**Sydney Metro Pitt Street South OSD
Stage 1 Modification (SSD 8876 MOD 2) & Stage 2 (SSD 10376)**

Attachment A

## SOUTH FACING VENTILATION SLOT

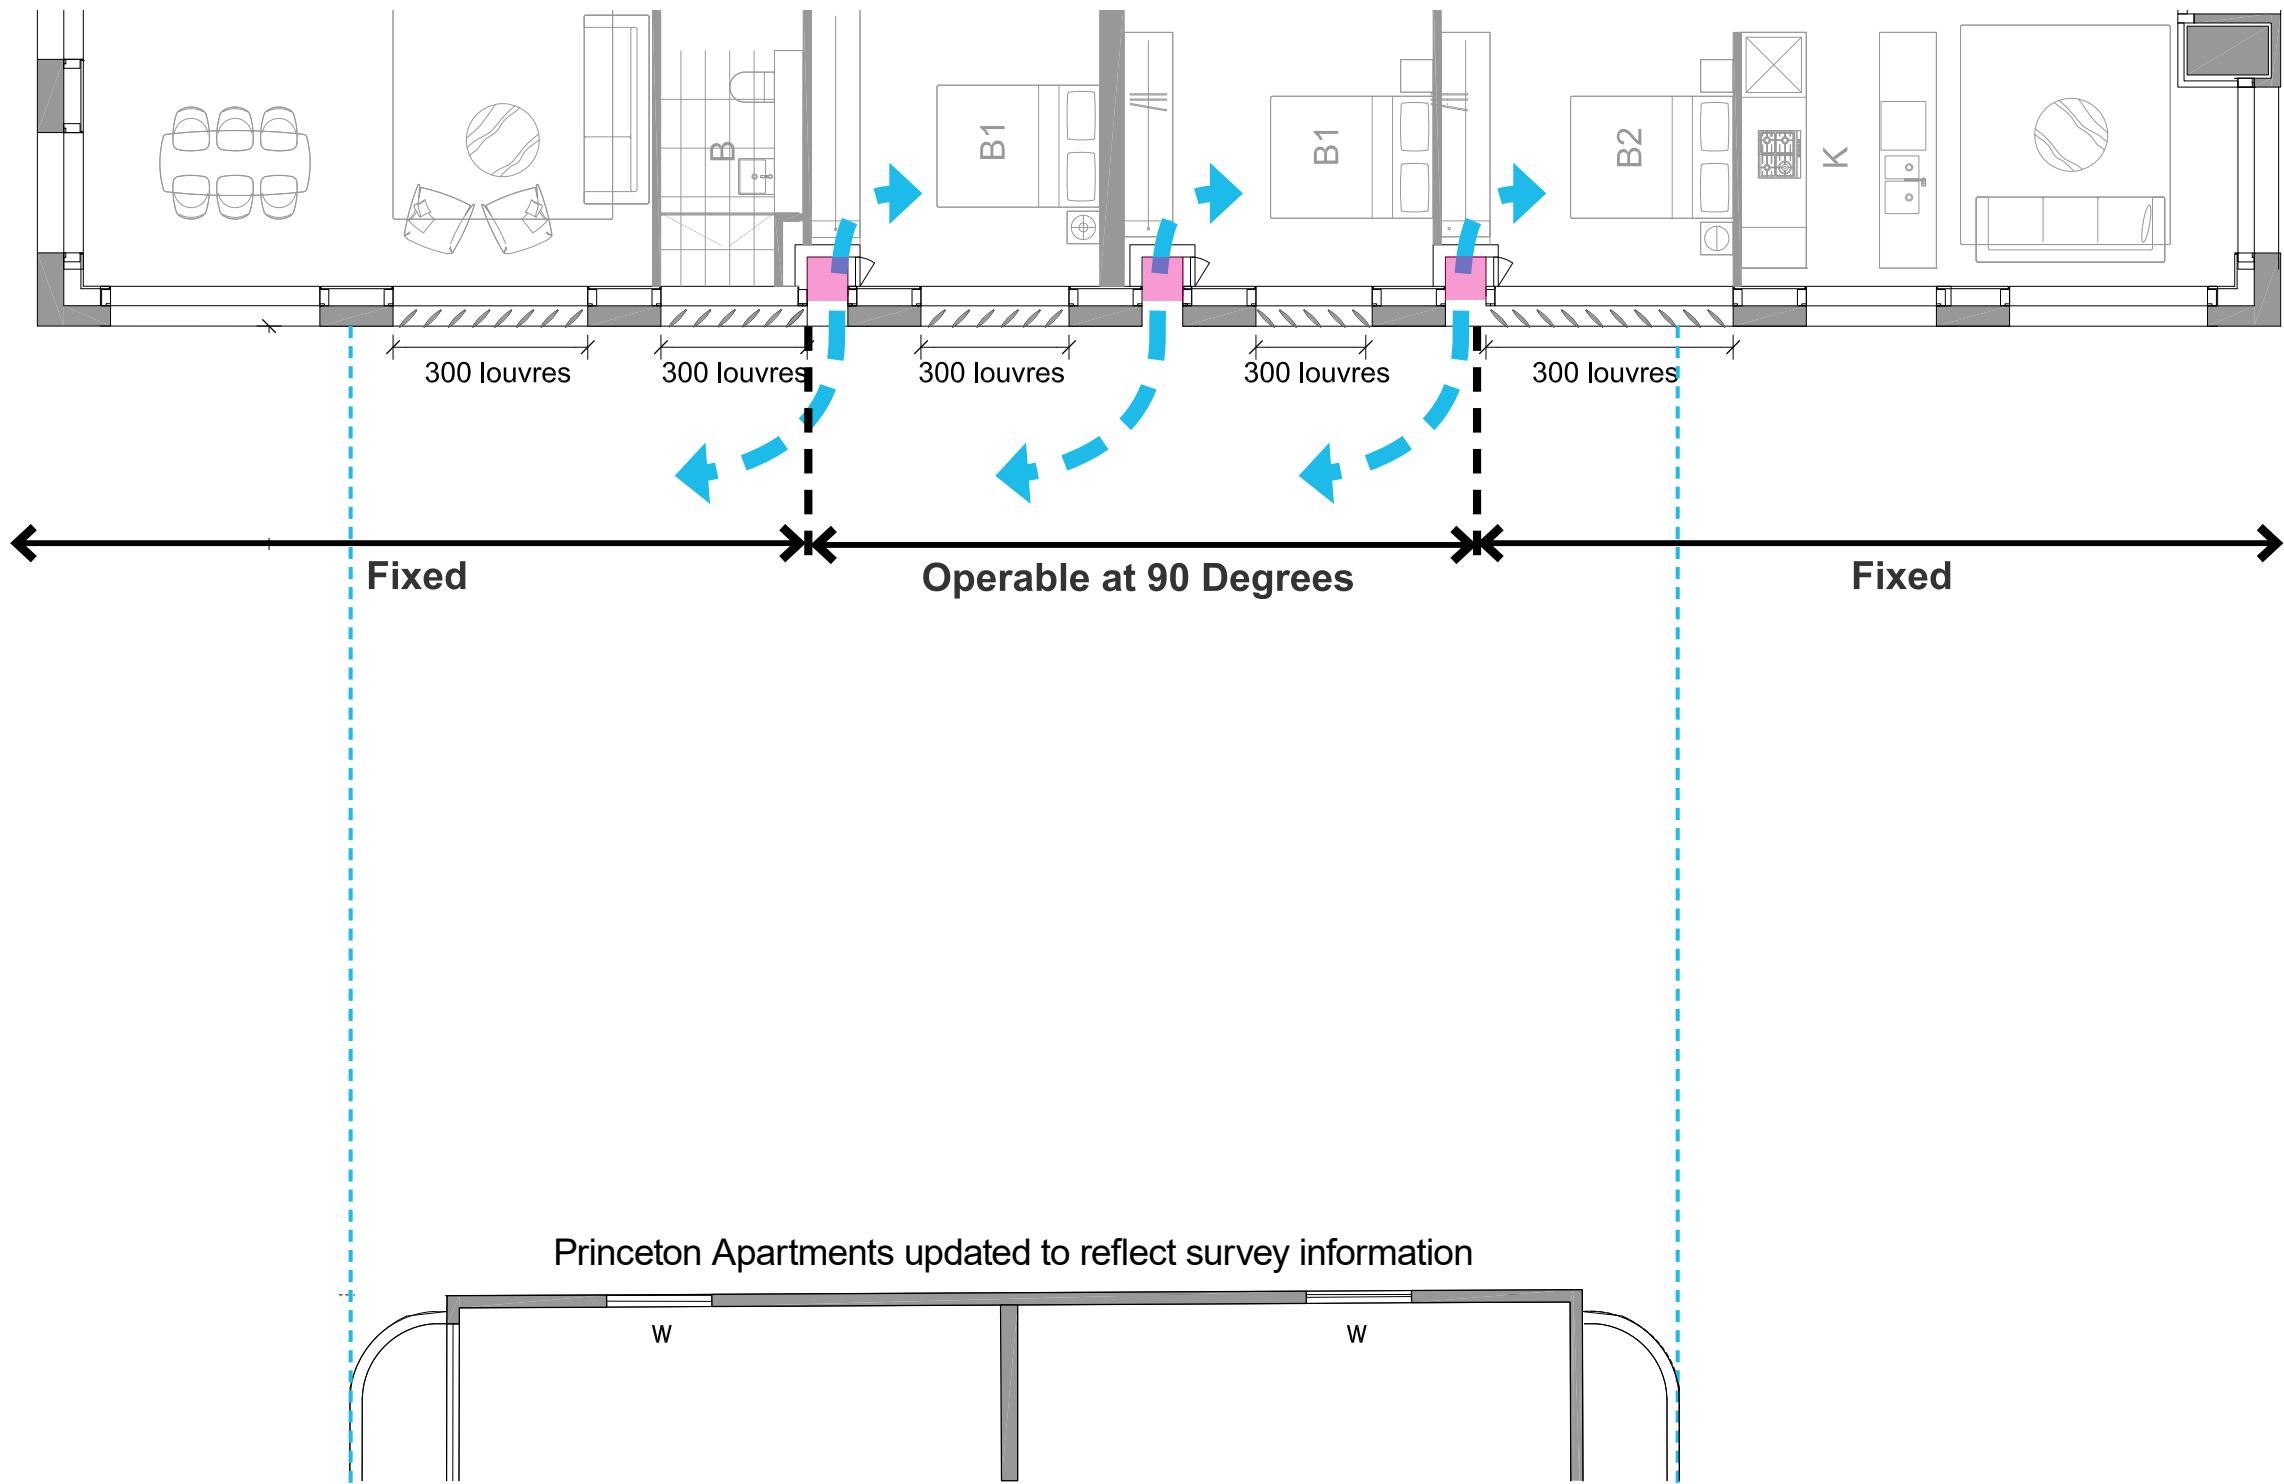
- the appropriateness of the location and design of the proposed communal open space adjacent to the Princeton Apartments on Level 6
 - any potential maintenance and acoustic issues from the proposed ventilation slots for south facing units
